FINAL DRAINAGE REPORT

LIQUID WASTE FIELD
OPERATIONS BUILDINGS

RE: GRADING PLAN AND DRAINAGE REPORT FOR THE LIQUID WASTE
OPERATIONS BUILDINGS, SUBMITTED MAY 19, 1989, FOR BUILDING
PERMIT APPROVAL (P-13/D1)

RE: GRADING PLAN AND DRAINAGE REPORT FOR THE LIQUID WASTE
OPERATIONS BUILDINGS, SUBMITTED MARCH 2, 1989, FOR BUILDING
PERMIT APPROVAL (P-13/D1)

TITLE: DRAINAGE PLAN					
APPROVALS	ENGINEER	DATE	APPROVALS	ENGINEER	DATE
City Engineer			Liquid Waste		
A.C.E. - Design			Traffic		
A.C.E. - Hydrology			Water		
DRAWING NO.	3410	MAP NO.	P-13	SHEET	OF

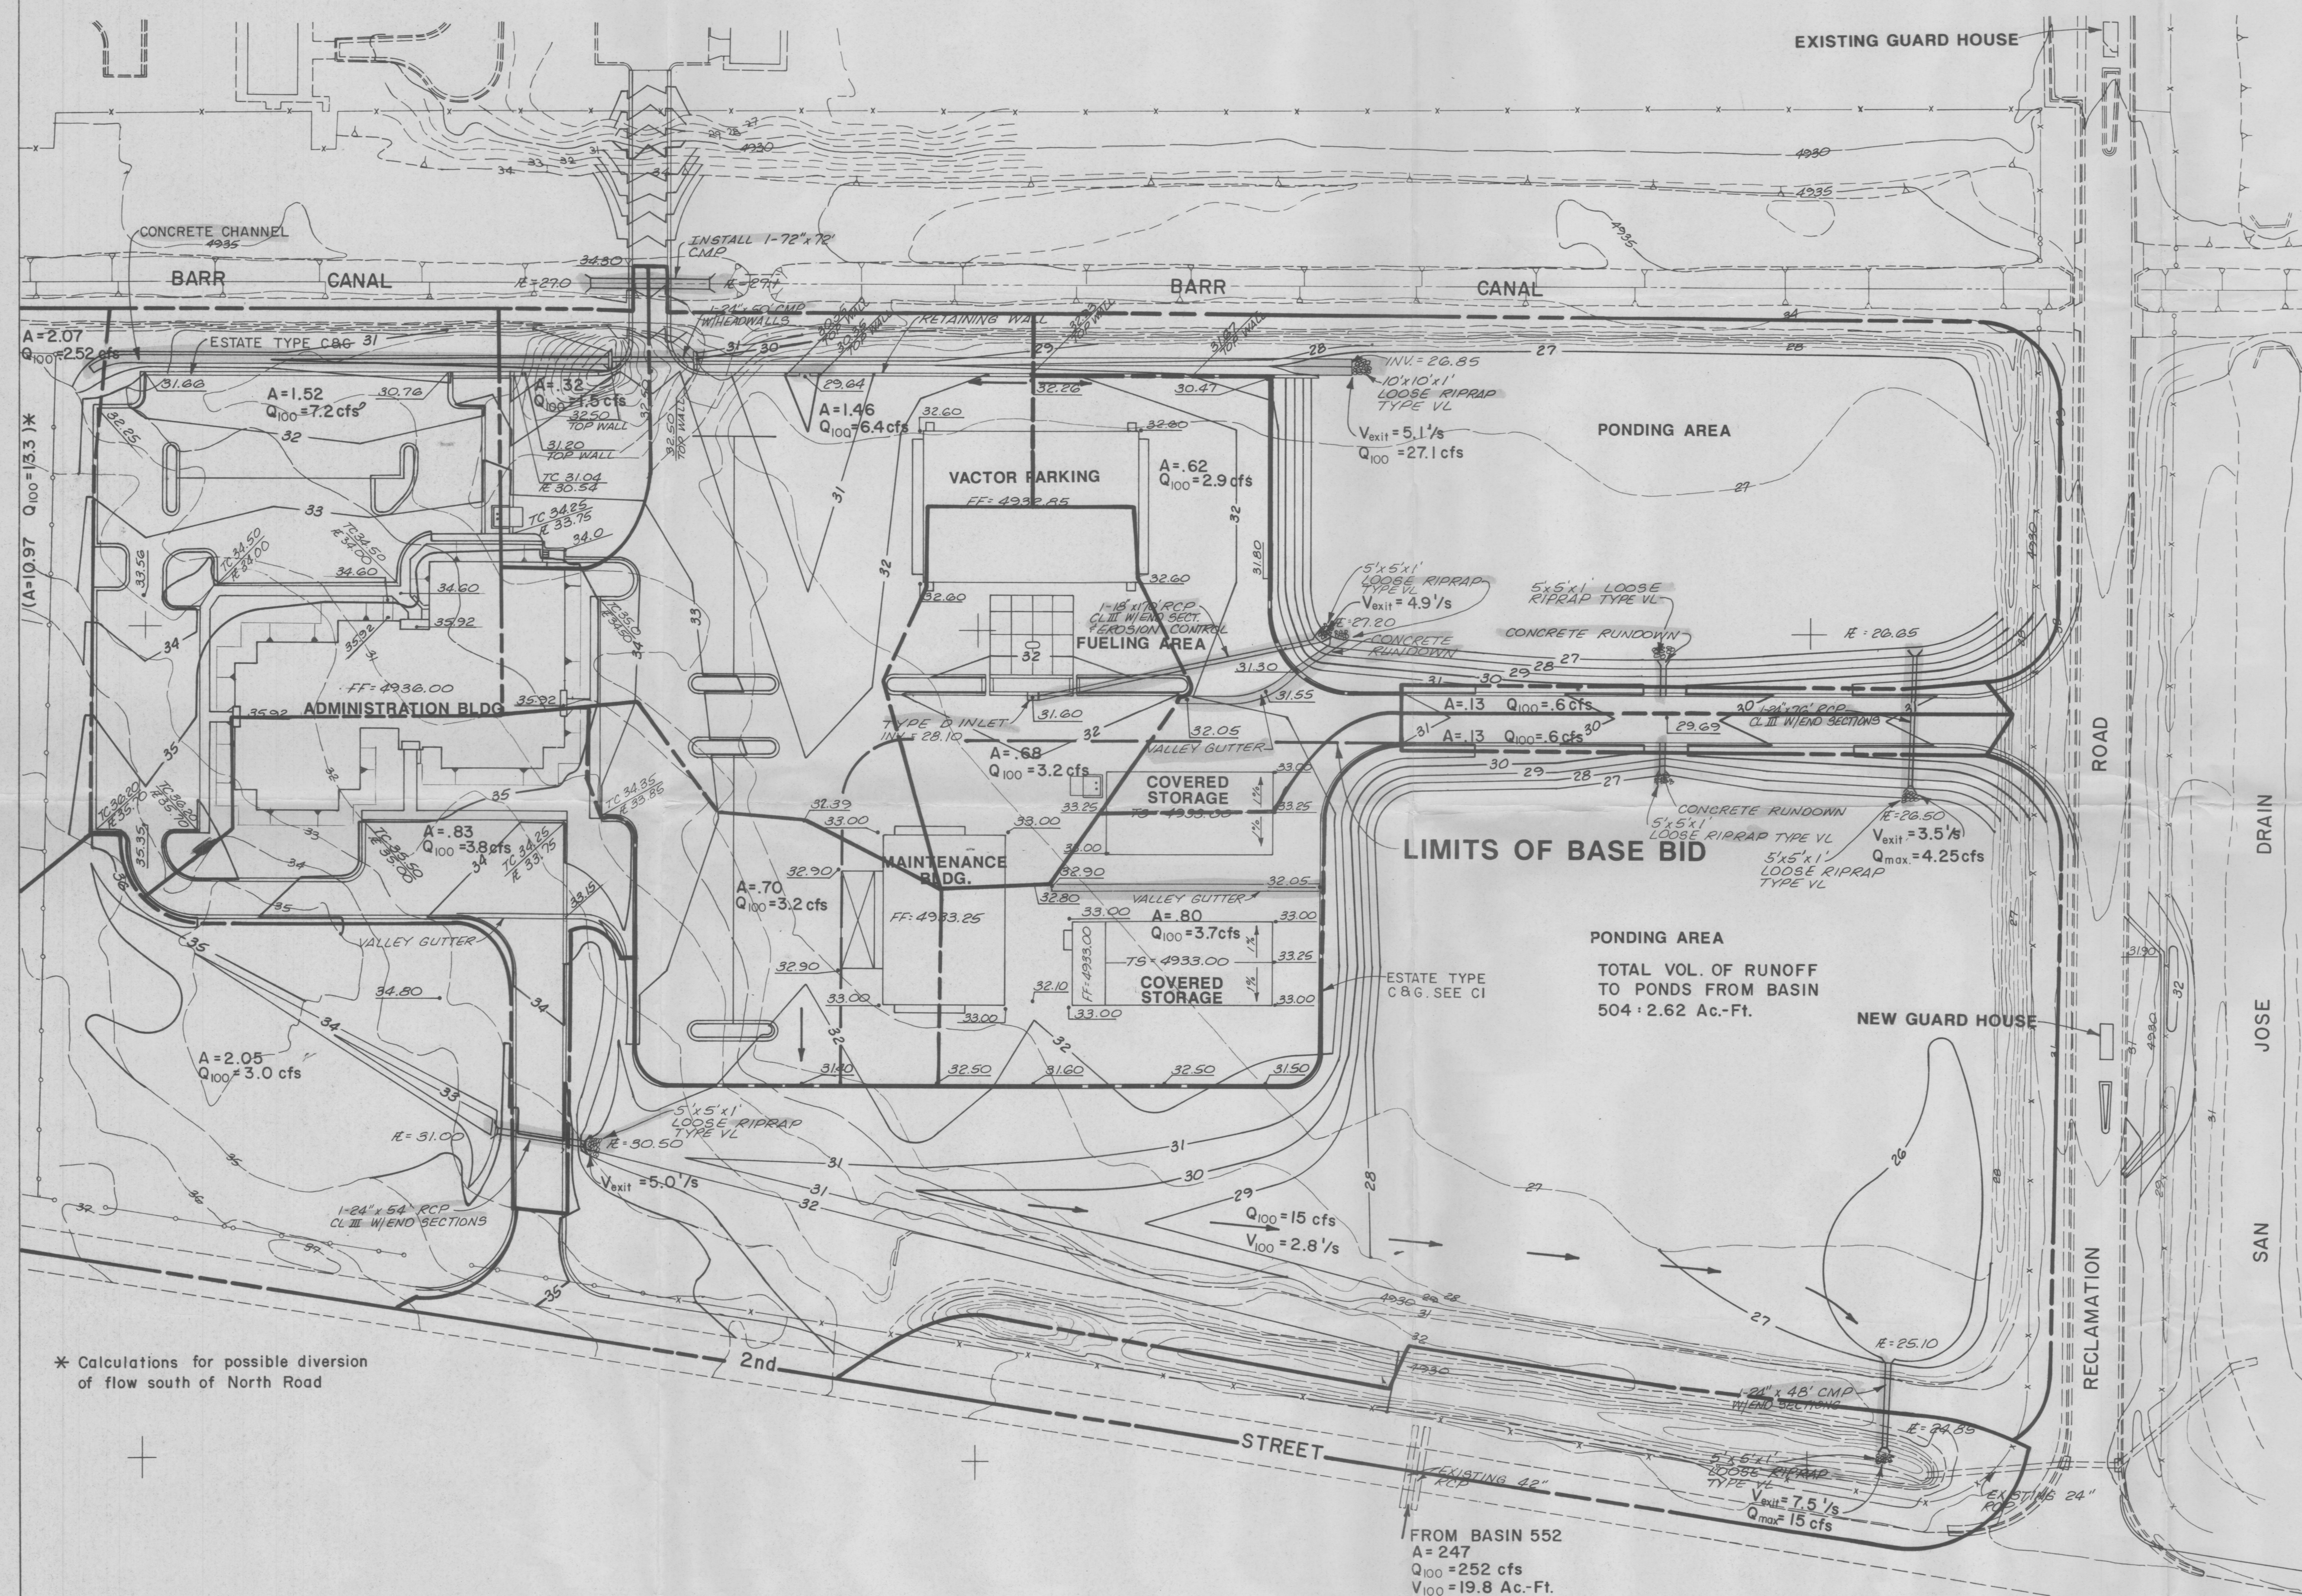
1. I didn't understand from reading the report the reason for sizing the ponds to hold a maximum of 13.4 acre feet, when by calculation, the site should generate only 2.5 acre-feet. It appears that the ponds could hold the site's runoff plus the existing runoff from Basin 552 (8.0 acre feet), but I'm not sure I understand how much area you intend to drain to them.
2. The wisdom of having a sumped drainage inlet in the refueling area isn't entirely clear to me. Fuel spills and other contaminants will have free access to the ponds and the water table.
3. Please provide storage routing calculations for the existing pond at the east side of the property to insure that your plan will not exceed its capacity.
4. Please define the drainage basins on the plan.
5. Please show the offsite basin(s) on the drainage plan, and quantify the peaks and volumes.

1. The lengths of RCP or the slopes at which they will be laid;
2. details of the concrete rundowns and pipe outlets into the ponds;
3. calculations for, and details of the erosion protection necessary throughout the site;
4. the detail of the southwest corner of the site at the line where water leaves the paving and enters the concrete 'V' ditch;
5. a detail of the curb break along the west side, and the same for the area just east of the maintenance building, for which the curb break is not shown;
6. the surface treatment for the ponds, their grading to provide positive drainage, and a low flow channel for minor flows.
